**Consultation Response from KC,
Trees**

2024/93094 The Willows, Hallas Road, Kirkburton, Huddersfield, HD8 0QG

Discharge of details reserved by conditions 4 (materials), 5 (boundary treatments), 6 (Phase I Desk Study Report), 7 (Phase II Intrusive Site Investigation), 8 and 9 (Remediation Strategy), 10 (Verification Report), 14 (Tree works) on previous permission 2023/92346 for erection of dwelling and associated alterations

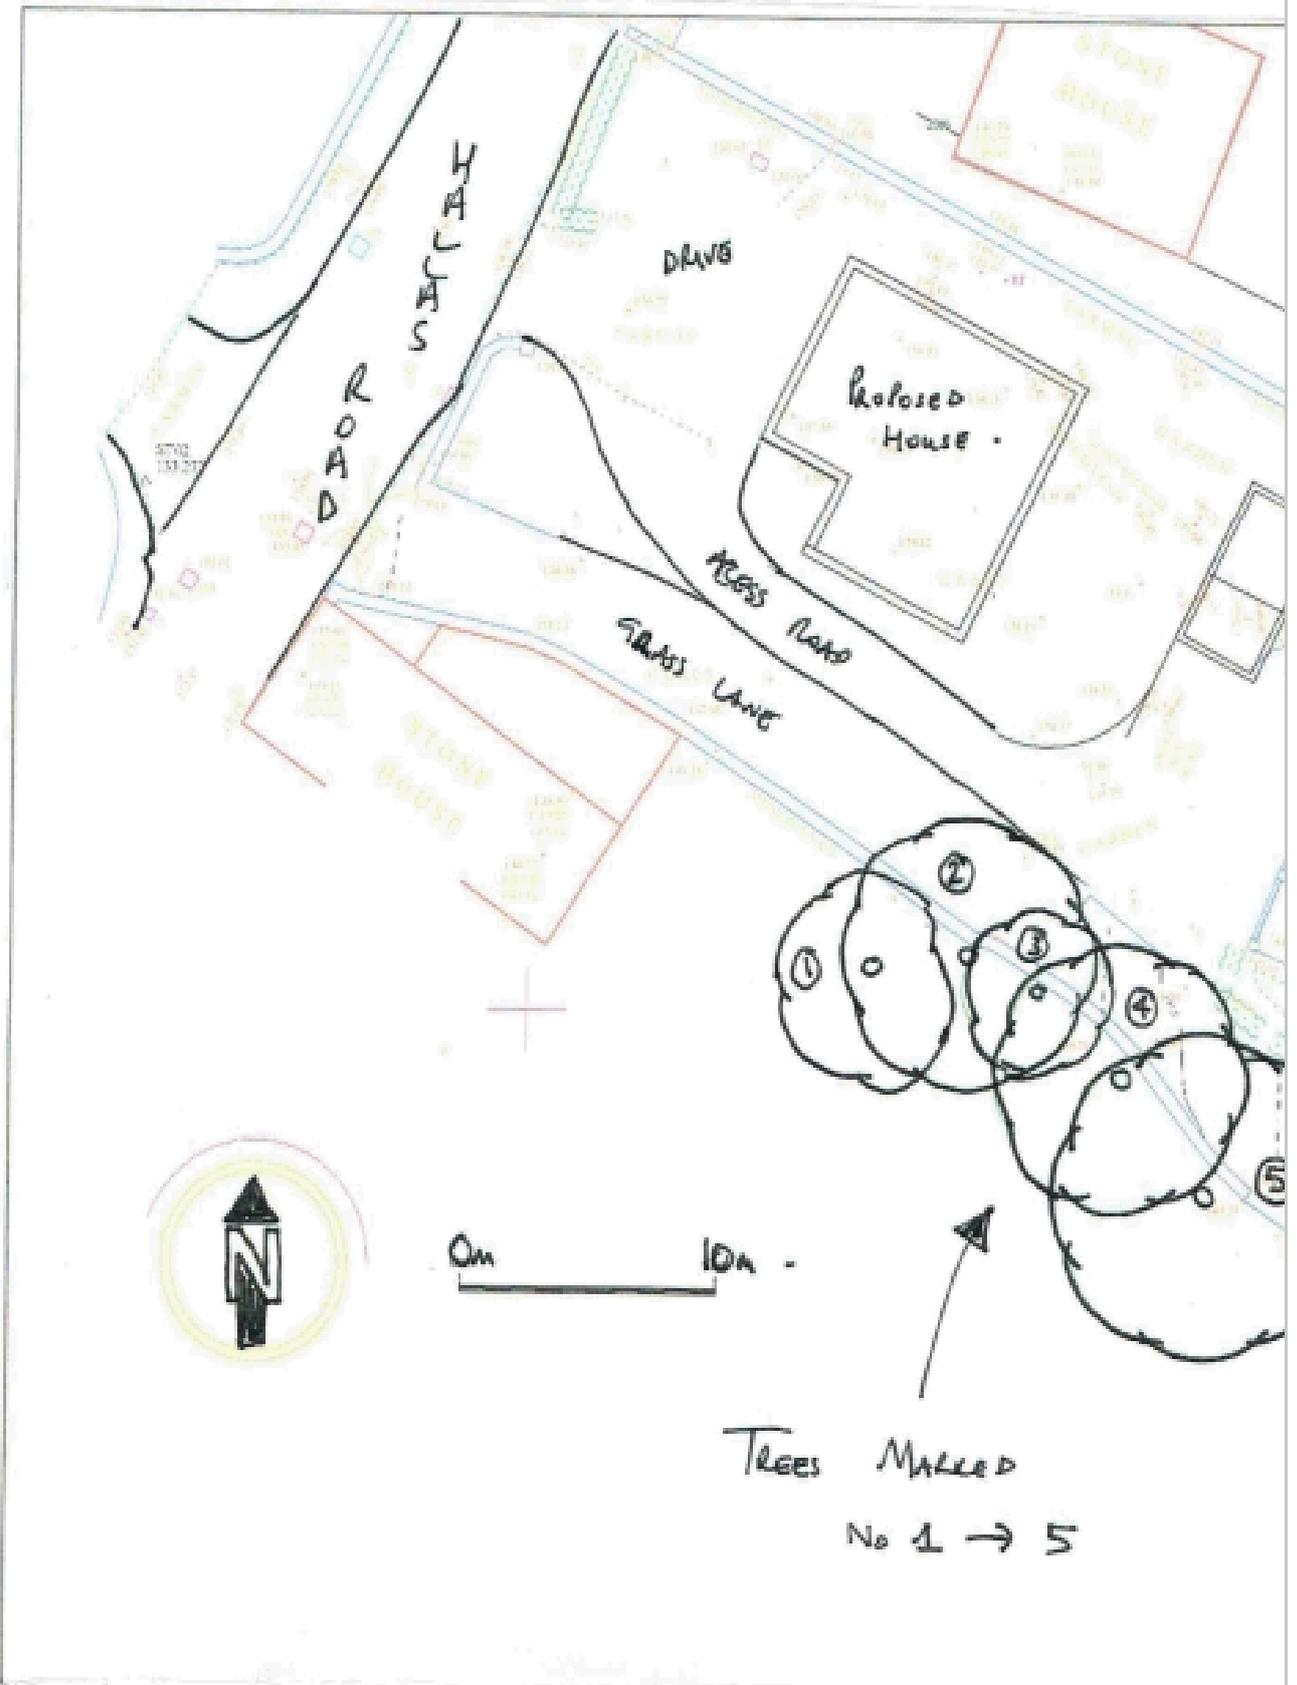
The proposed tree work is excessive and unnecessary to facilitate the development. There is still no objection to the proposed development as it shouldn't impact on the trees however the permission to prune these trees is rejected.

The proposed tree work to T5 is excessive and alternative remedial action hasn't been explored before suggesting the removal of the tree closest to the existing building. Also the proposed work to tree T4 would leave the tree completely one sided and likely unviable in the future. The descriptions of work are also too vague and need to be more specific with their intended work. If the applicant still wants to perform lesser works on these trees they should do so via a section 211 notice on the Kirklees website: [Apply to work on trees | Kirklees Council](#)
